Agenda Item: Construction Traffic and Access

From [REDACTED], Gt Staughton Parish Council [REDACTED]

APFP Reference
Regulation 5(2)(a)

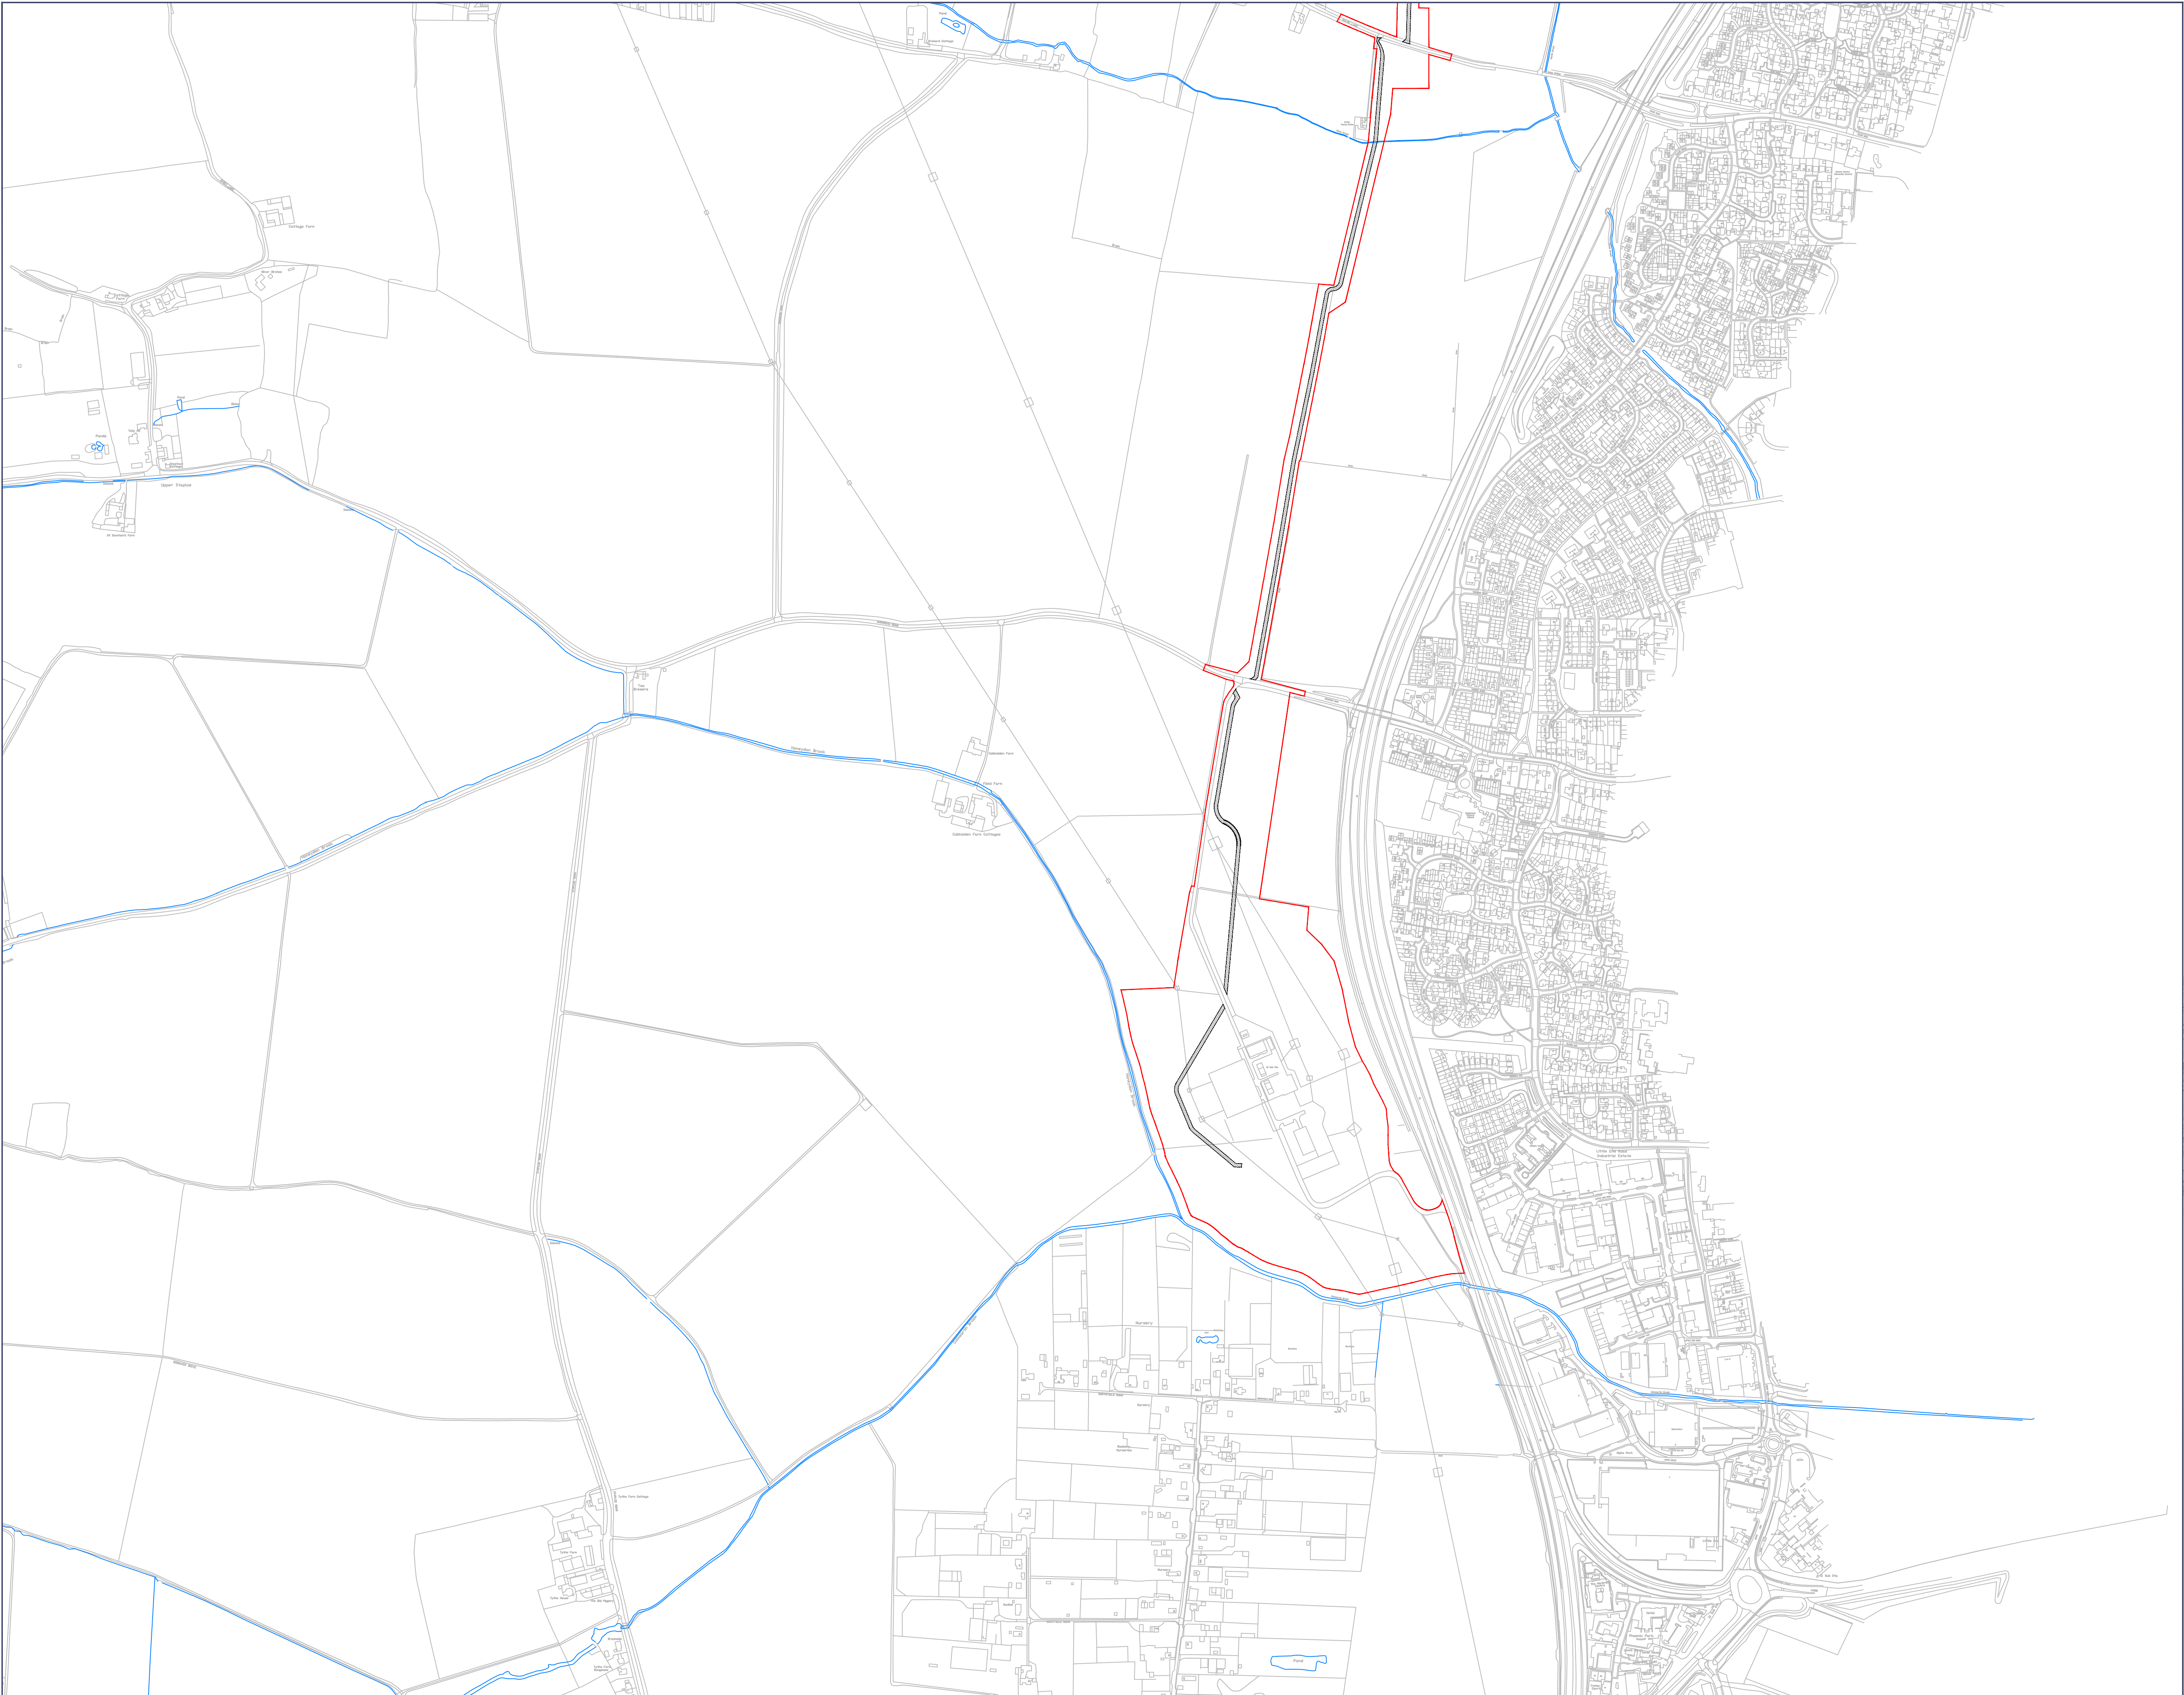
We understand that Brockwell's intention is for all the site traffic to come from the A1 along the B645 and enter the point at SA16. However, we would like to see a commitment that this will be strictly enforced otherwise we suspect that construction traffic including HGVs will be tempted to take the shortcut from SA12 back through the village in a way that would be exceedingly dangerous and disruptive:

B645 (MAIN ACCESS SA16 to site D). This stretch of road is considered locally to be extremely dangerous:

Gt Staughton Road towards Pertenhall, around SA12 and the Zantra site

This minor road is not suitable for HGVs, being barely more than 5m of tarmac wide in some places, with two passing HGVs requiring **5.7m** of width to clear their mirrors safely. Also the use of this stretch of road will make it very tempting, without very

strict enforcement, for construction traffic to take shortcuts through the village. It would be better if this stretch of road was not used at all for construction traffic.

We are concerned that the project will cause obstruction on the B645 (especially around the main site D access SA16) which is the route to and from work school and shops for many parish residents. Any blockages, hold-ups or temporary traffic signals will come at a significant economic and social cost to local residents.

We are concerned that the proposed access route appears to travel over the newly designated Roman Town Scheduled Monument, with cable trenching potentially under it. To avoid risk of damaging the monument, it would be better if the access route and cabling should be kept well away from the monument

2. **A Pre-Commencement Road Survey:** A legally binding 'Section 106' agreement for the developer to repair all road and verge degradation.
3. **A Physical Width Audit:** A requirement for the Applicant to prove, via 'Swept Path Analysis', how two HGVs can pass on Pigs' hill on the B645 and on Great Staughton Road without leaving the tarmac."

4. **Construction Traffic should not use the 'Gt Staughton Road'**, and instead should keep to a purpose built access track off the road network
5. **Construction Traffic and cabling should be kept well away from the scheduled monument.**
